Recommendation Report for Planning Permission for Works or Extension to a Dwelling

REF NO: LU/71/26/HH

LOCATION: 41 Henry Lock Way
Littlehampton
BN17 7FB

PROPOSAL: Conversion of garage to accommodate bedroom and ensuite.

**BEDROOM AND ENSUITE  
ARRANGEMENT PROPOSED**

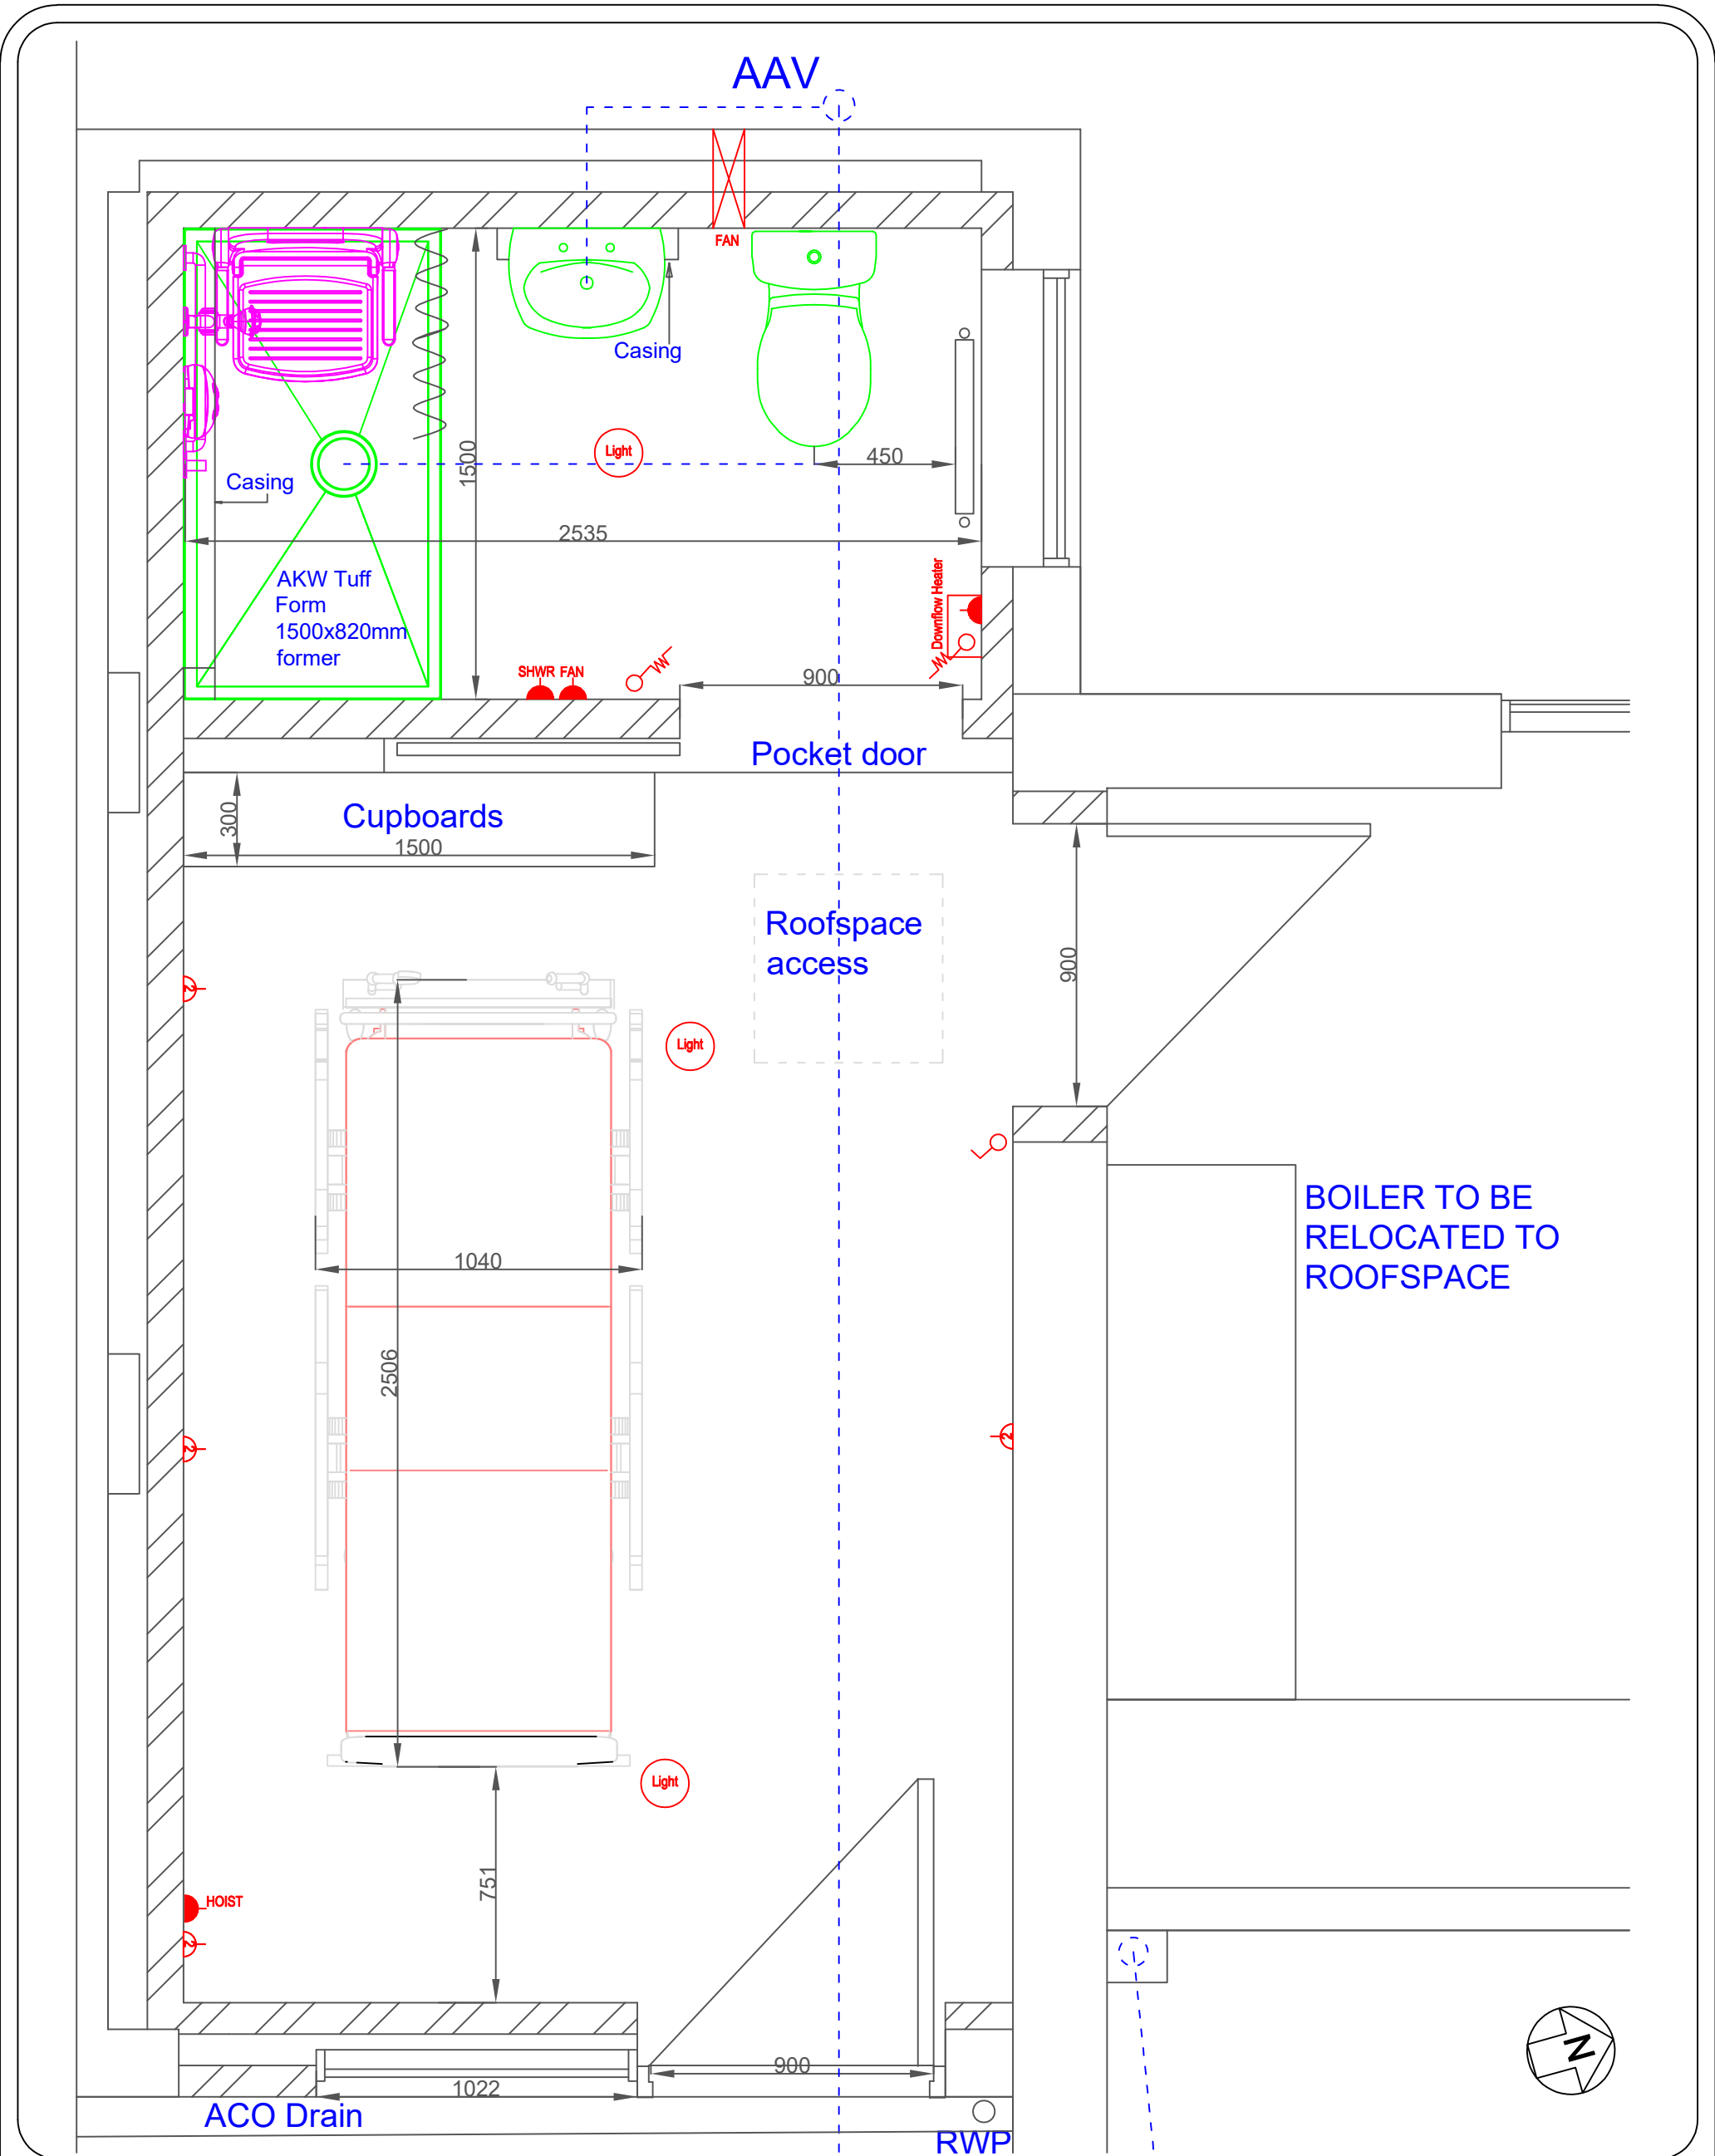
The resulting internal floor area would be approximately 10m², with an internal width of 2.6m. This exceeds the minimum dimensions set out within the Nationally Described Space Standards (NDSS) for a single bedroom. The proposal would therefore be in accordance with Arun Local Plan (ALP) policy D DM2.
